Subject: RE: Planning Re-Consultation on: M/39/24/DOC

Hi Sam the Council have come back to me with a further information request for 117 Elmer Rd.

TRENCH AND BEDDING DETAILS

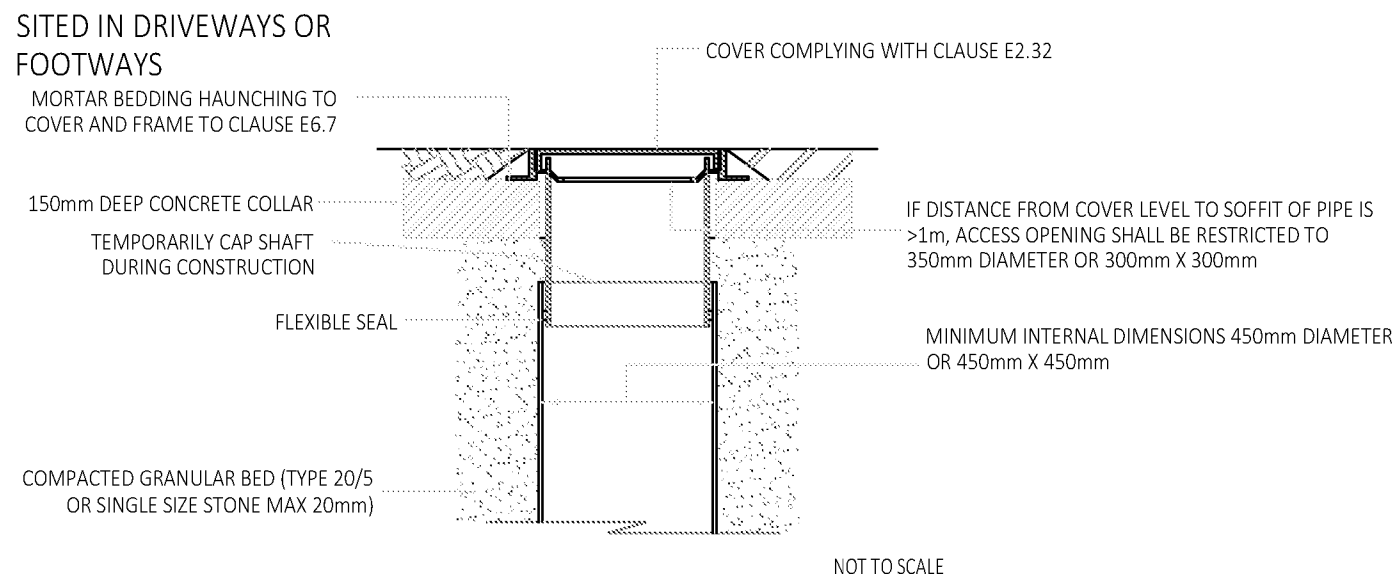
33 – *“Pipe bedding details – specify depths of cover associated with each bedding type.”*

The associated depths are included within the details sheet ‘CIV02 P1’ beneath the pipe bedding detail in yellow. If you need anything further please let us know.

SOAKAWAY UNDER PERMEABLE PAVEMENT STANDARD DETAIL

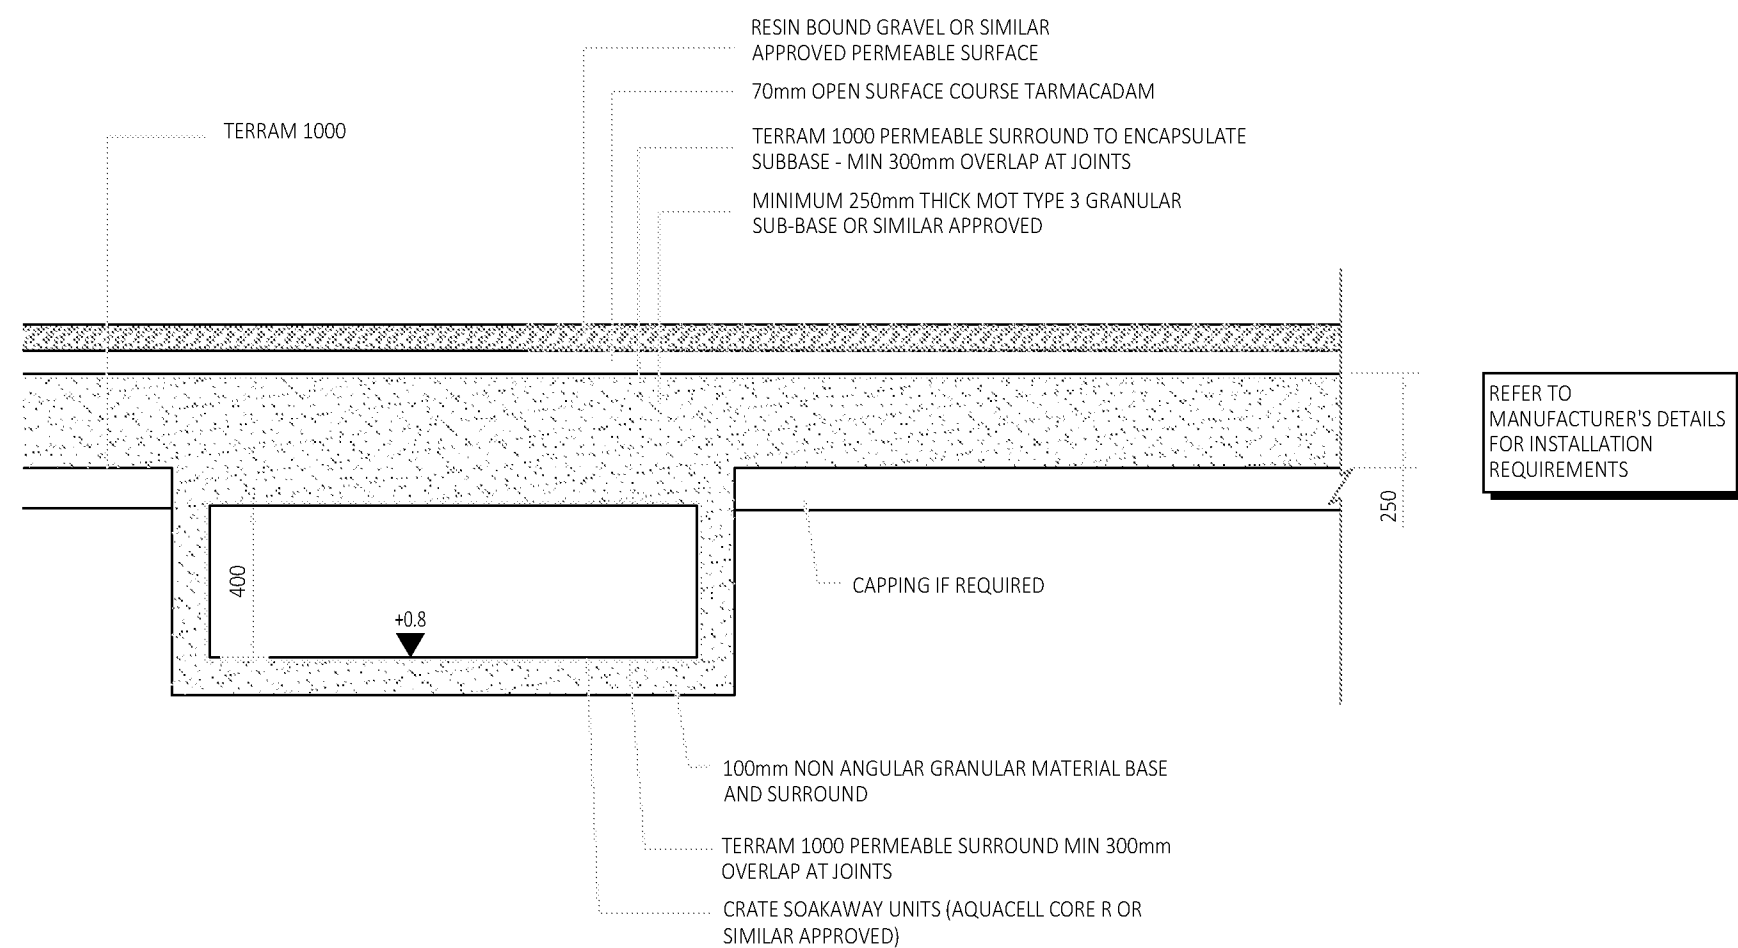
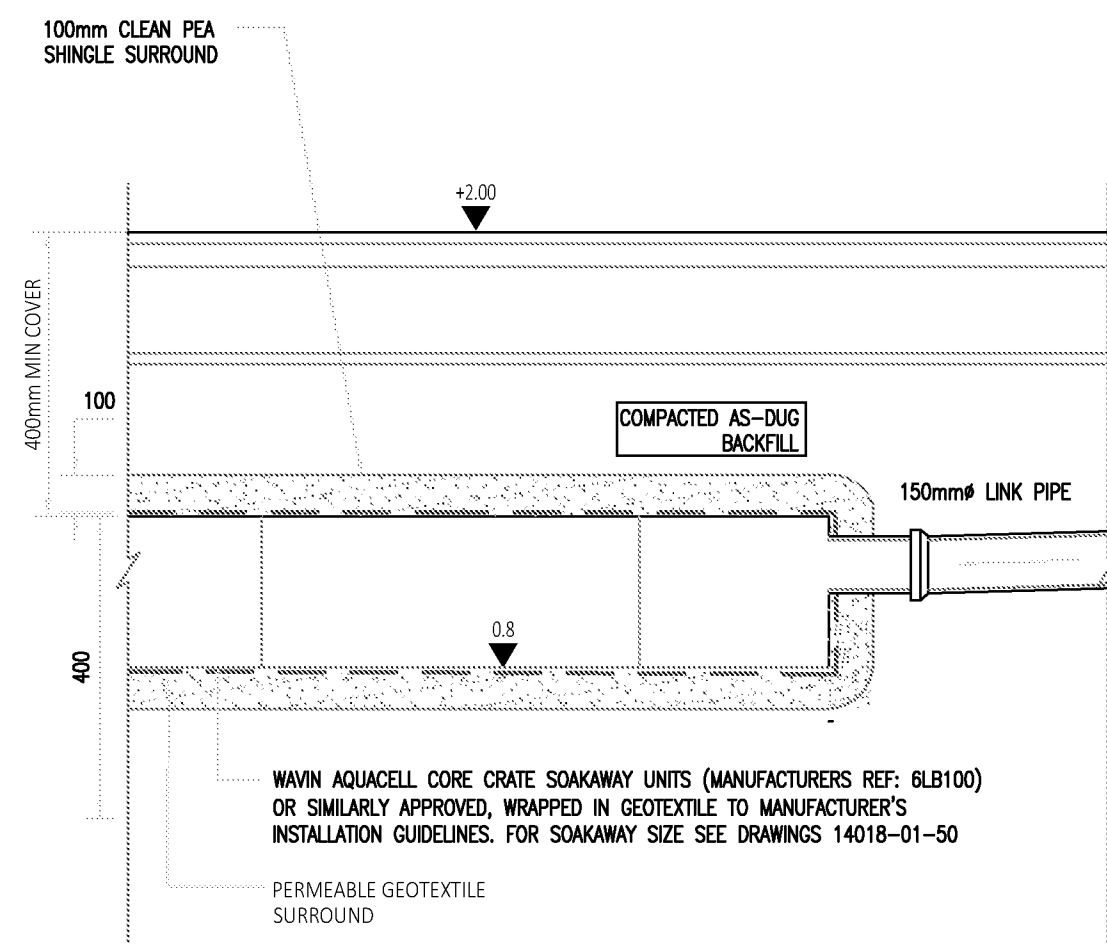
30 - *“Please remove the 90 degree option from construction detail, as 45 degrees provides better hydraulics.”*

See attached corrected drawing CIV02 P1.

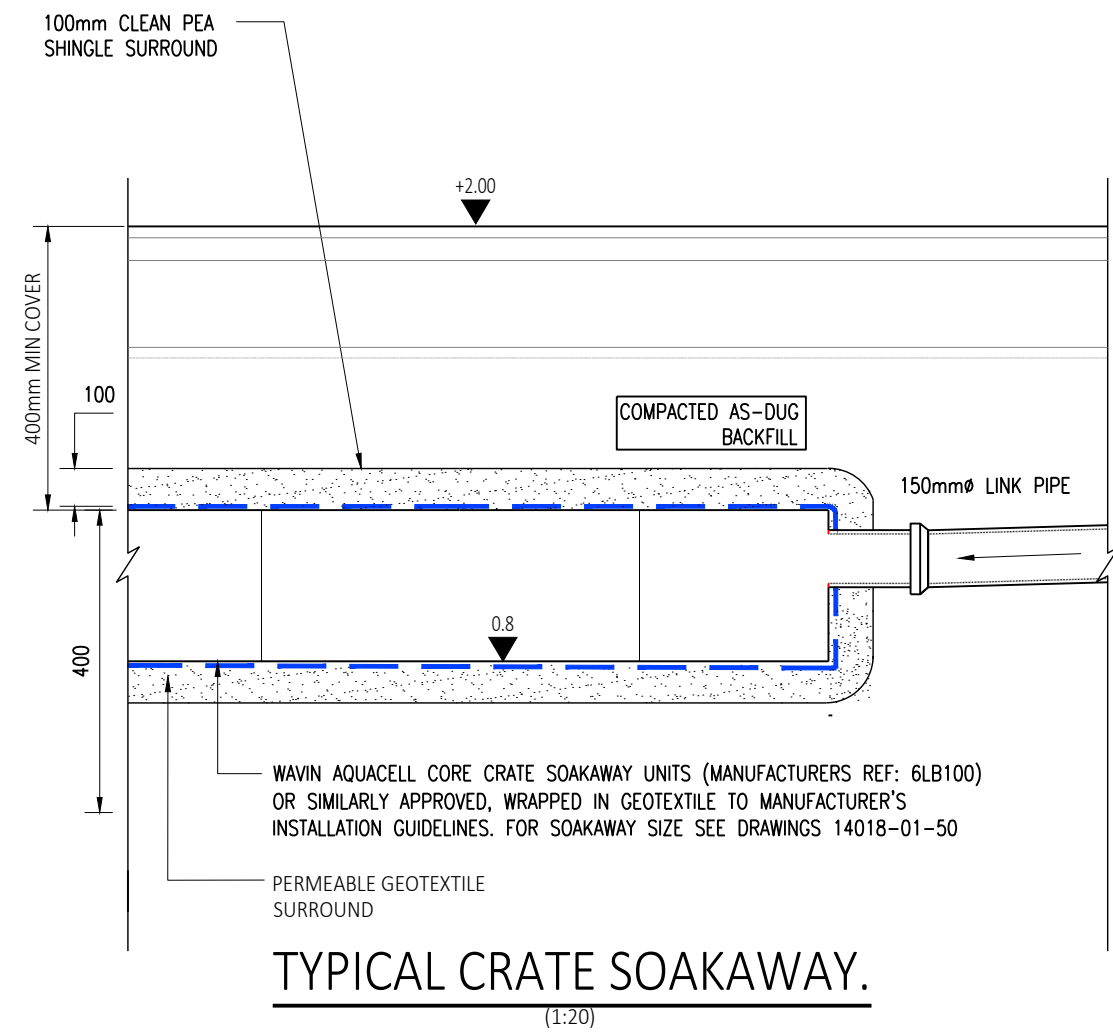
21 – *“Design revised. However, the layout plan shows the soakaway bases set at 0.4m AOD as opposed to 0.8m AOD. The construction details show it correctly. Please adjust accordingly.”*

See attached corrected drawing CIV01 P1.
